APPLICATION A/38/17/L

Site Address: 6 Longback Cottages Arundel Road Angmering BN16 4JT

**ADC Planning Consultation
Response from the Historic Buildings Adviser**

Application Number	A/38/17/L
Address	6 Longback Cottages, Arundel Road, Angmering, BN16 4JT
Description	Application for listed building consent for a two storey side extension, relocation of existing shed, driveway to be laid with re-claimed brick, replacement of 7 No. windows like for like, relocation of main bathroom & new staircase.
Case Officer	Anita Gardner
Site Visit

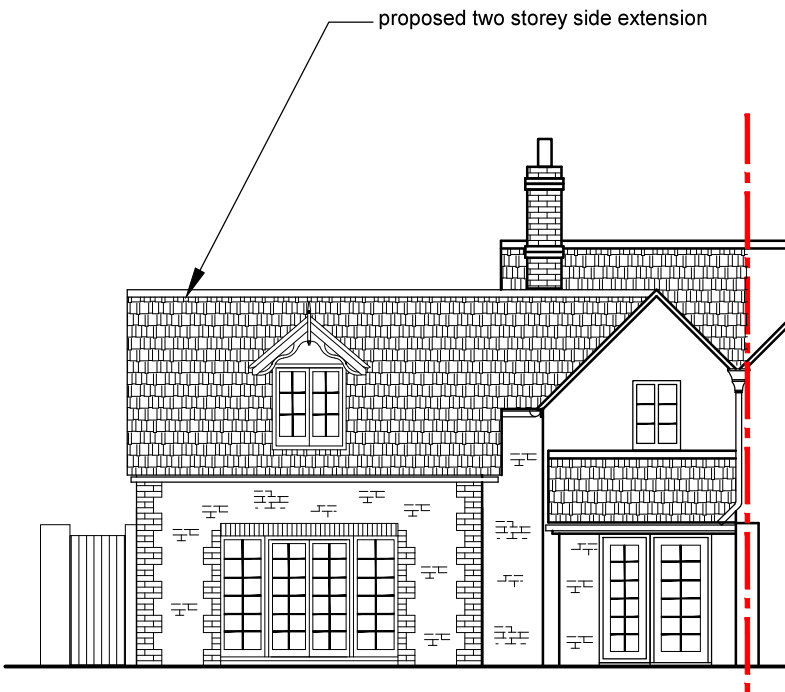
Unfortunately the proposed design represents a threat to this scale, but also the simple form and plan of the cottage which is part of the building's special interest. An extension of this size and nature will therefore be harmful to the listed building, but also the integrity of the whole group as well as the Conservation Area.

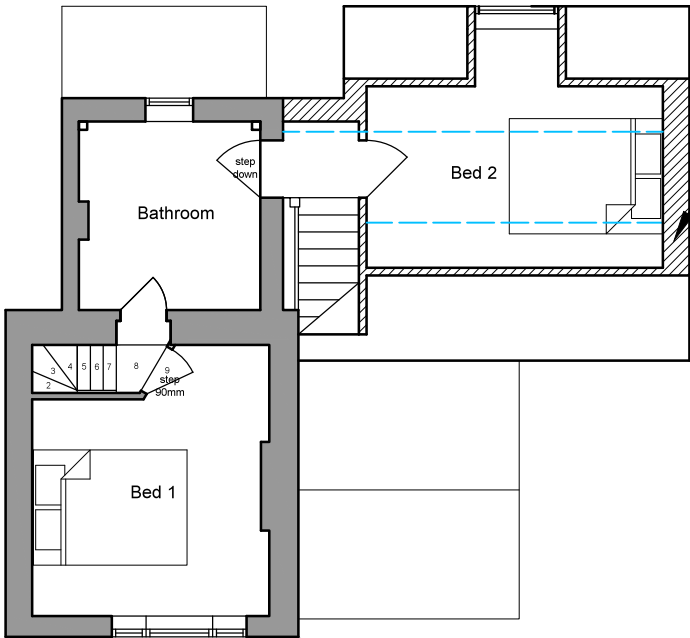
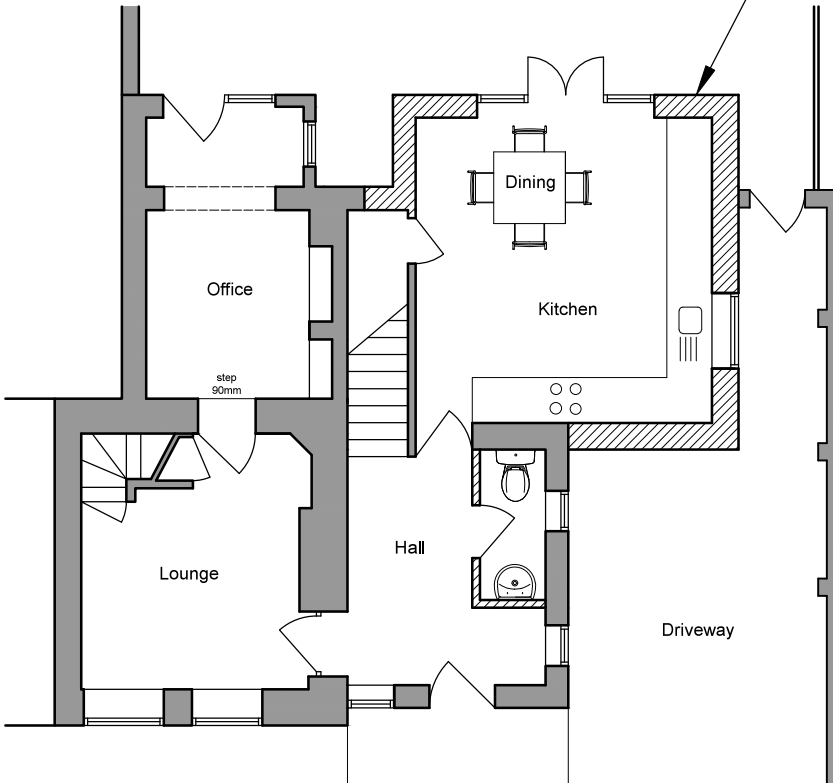
The scale of the dwellings is an important part of their special interest, not least because they were formerly known as the Poorhouses and therefore would not have been overly large. They should therefore not be increased in size to a large degree, or sprawl greatly from the original plan.
